Ribchester Parish Council

PLANNING APPLICATION No: 3/12/0025

Application: One post mounted metal frame with metal swinging sign

At: STONEYGATE HOLIDAY CENTRE, STONEYGATE LANE.
RIBCHESTER

Stoneygate Welcome Sign

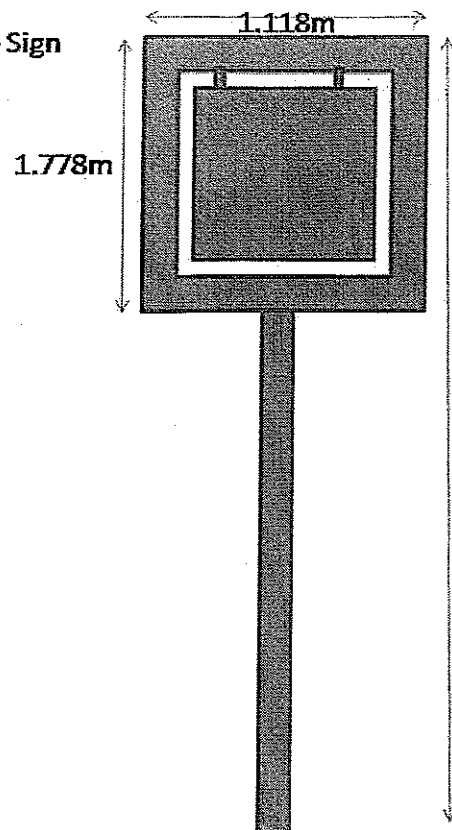
1. The submitted application is for a metal sign on a 16 foot high metal post to be sited near the entrance to the holiday centre close to the junction of Stoneygate Lane and Clitheroe Road. This junction has been the location of a number of fatal accidents in the last few years, caused in the main by excessive speed and poor visibility. The junction layout is of local concern and criticized both by the police and Coroner. The Parish Council is currently pressing the County Council Environment Directorate for further safety measures to be installed. Any further distraction at this point is to be avoided.
2. Secondly the size and location of such a sign is inappropriate in open country and close to the AONB. It will detract further from the character and visual amenity of the area,
